August 24, 2022

Project Name / File No.: White Barn Dental (Permit #: PA22-029)
Applicant: Titanium Office, LLC
Project Description: Administrative Review – Site Plan
Site Address: 8813 Soper Hill Rd, Marysville
Review: Applicant’s Response to (1st) Review

This letter serves as the Applicant’s formal response to the 1st review comments received from the City of Marysville on August 5, 2022 to our recent application materials submitted to the city on July 7, 2022. To ensure that each of the comments have been responded to, we have incorporated each of the City’s comments along with the Applicant’s response to each below. The responses below are to inform you that we have addressed each of the City’s comments so the review of the application may continue.

TITANIUM OFFICE, LLC
DENTAL OFFICE - WHITE BARN
PRELIMINARY SITE PLAN

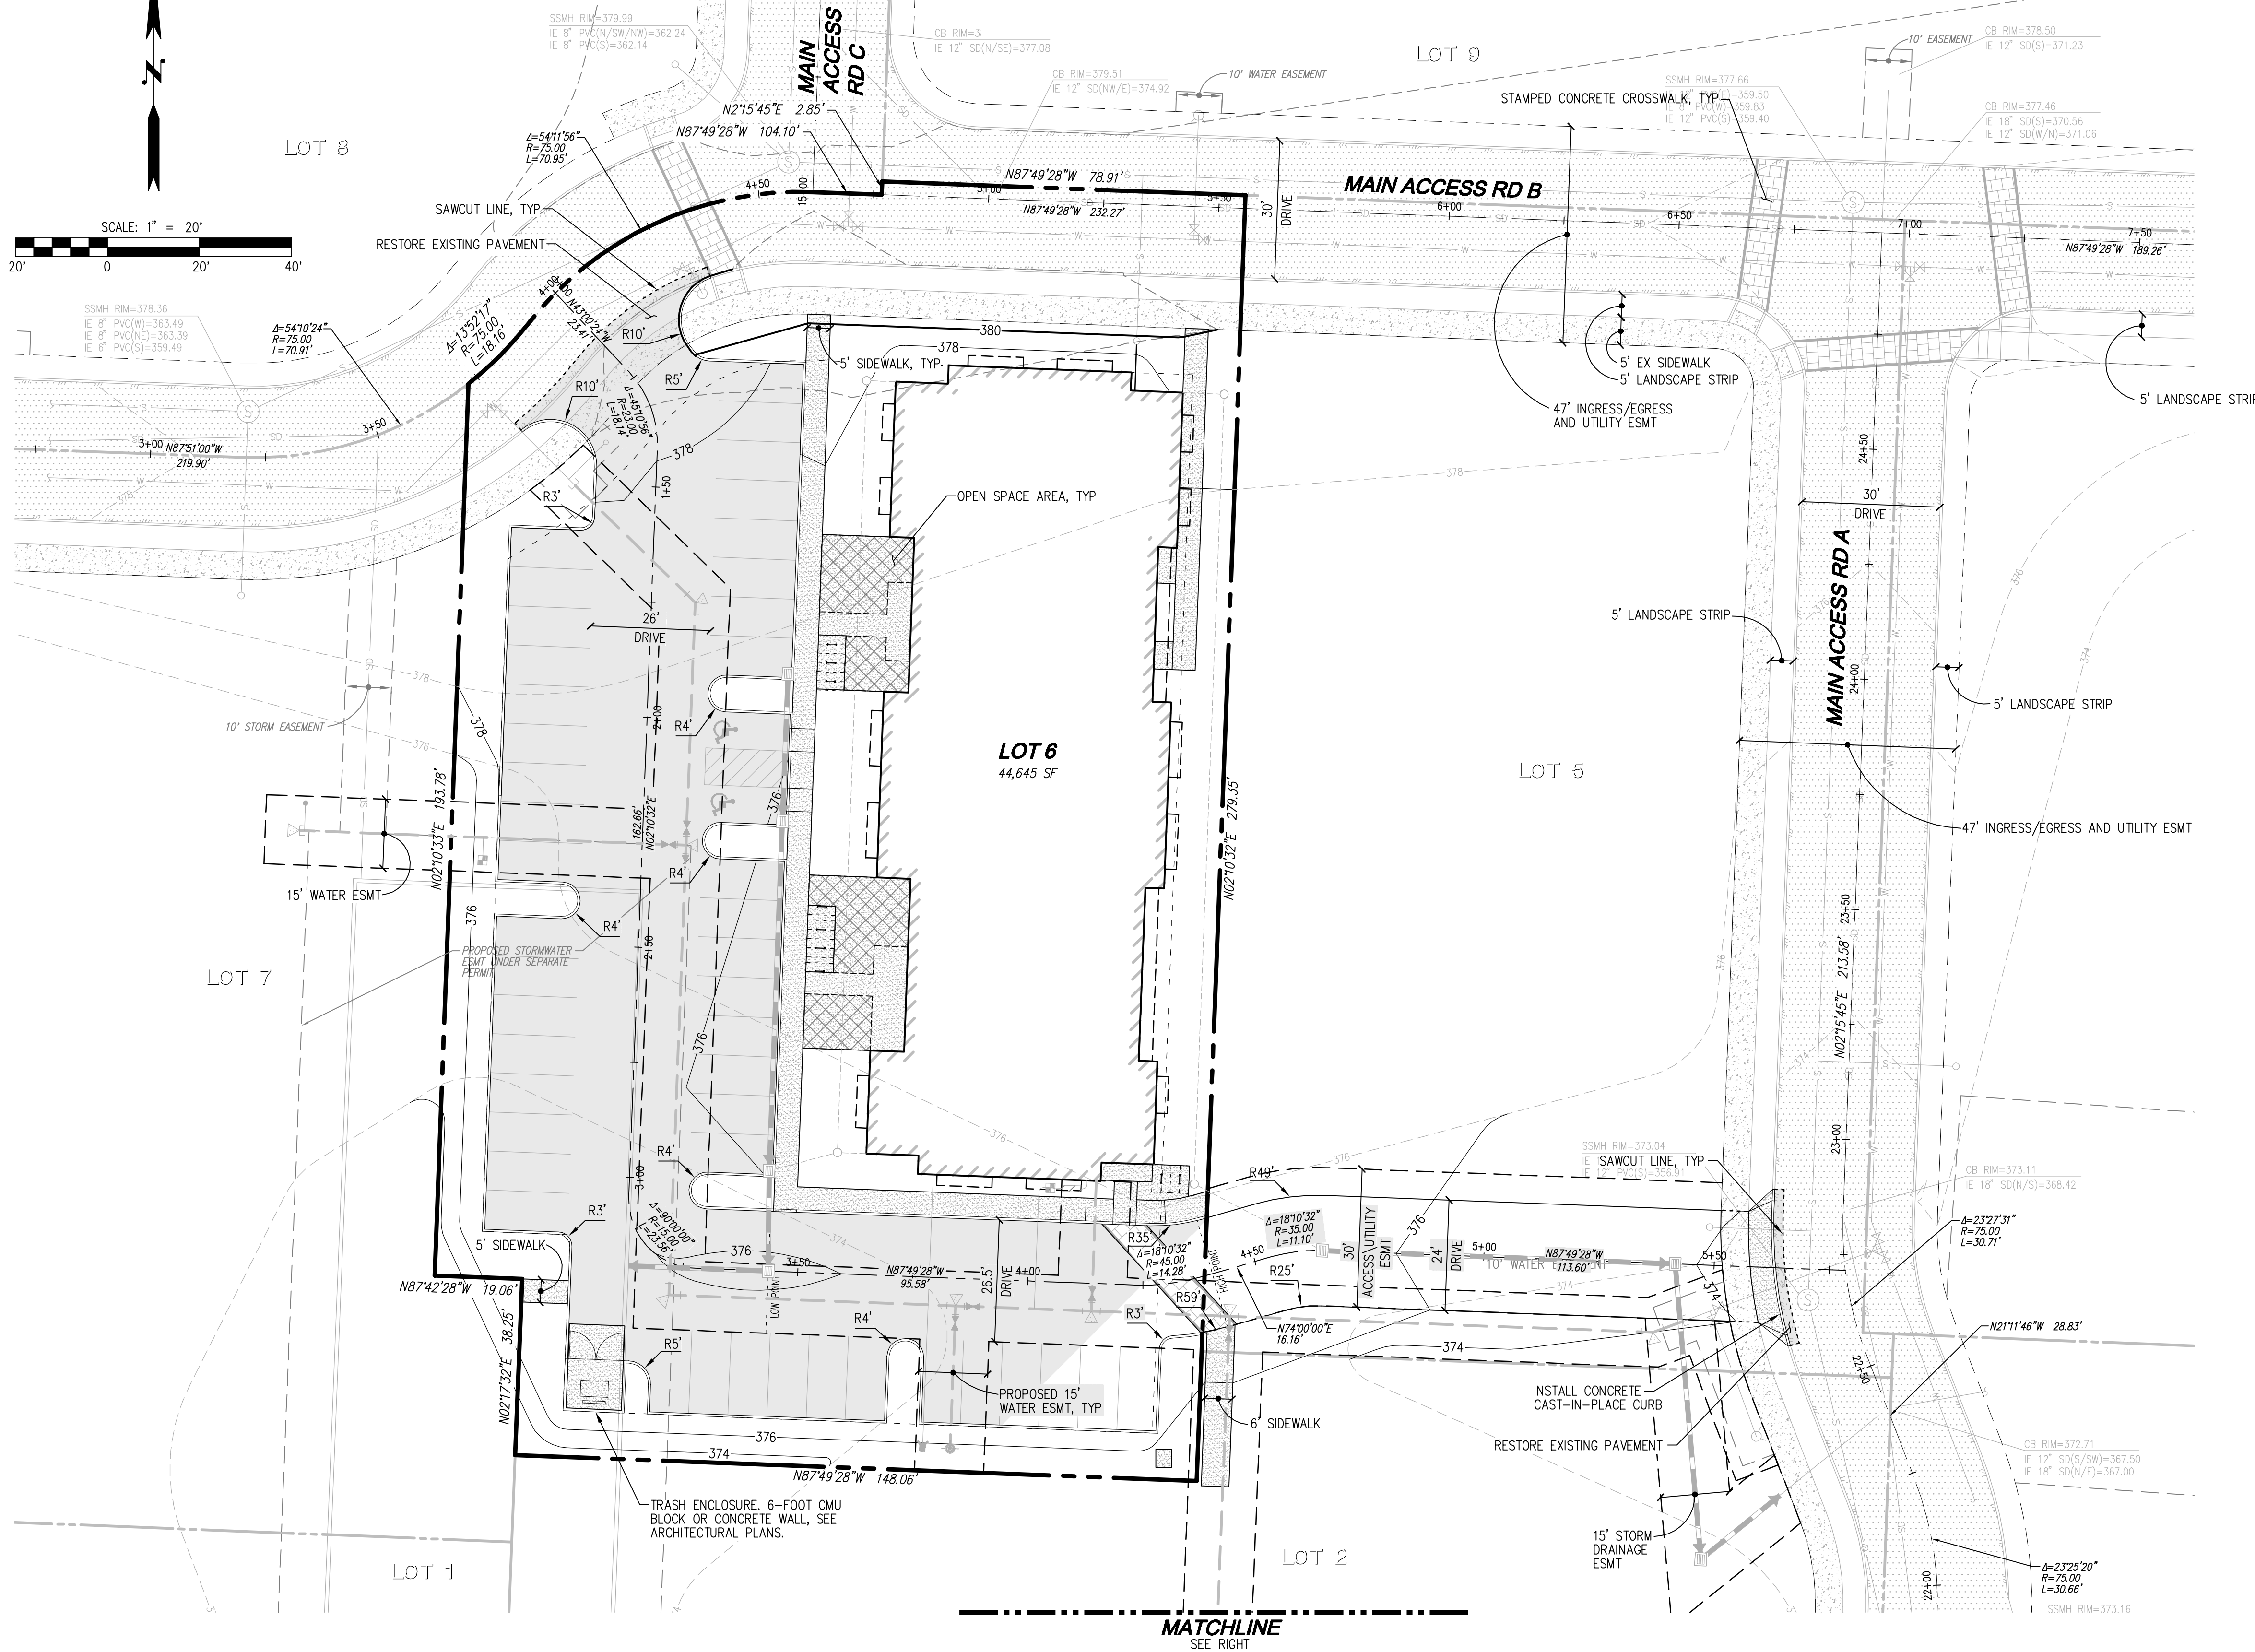
However, the provided Project Narrative and Site Plan appear to have different figures for the number of parking spaces required and proposed. Revise to clarify what is being provided, including bicycle parking.

Applicant's Response: The architectural and civil site plans have been revised to match.

6. **Drainage:** All projects in the city of Marysville must comply with requirements stipulated under the MMC 14.15.040 and 14.15.050.
- a. Stormwater drainage: The city has adopted the 2012 Ecology Manual as amended in 2014. As the project will be flowing to a system that has already been approved, the project will need to submit a stormwater site plan that is compliant with minimum requirements of 1 – 5. The report that was submitted is substantially compliant with the required standards. As noted in the report, a conveyance analysis will be required in the civil submittal.
 - b. A geotechnical report has been provided.
 - c. The maximum allowed impervious surface coverage for the Zoning designation is 85%. Please confirm if the current proposal meets this ratio.

Applicant's Response: Conveyance analysis will be provided in the civil submittal. Maximum impervious surface proposed for this site is 79.4% and is below the 85% allowance, detailed analysis will be provided in the civil submittal.
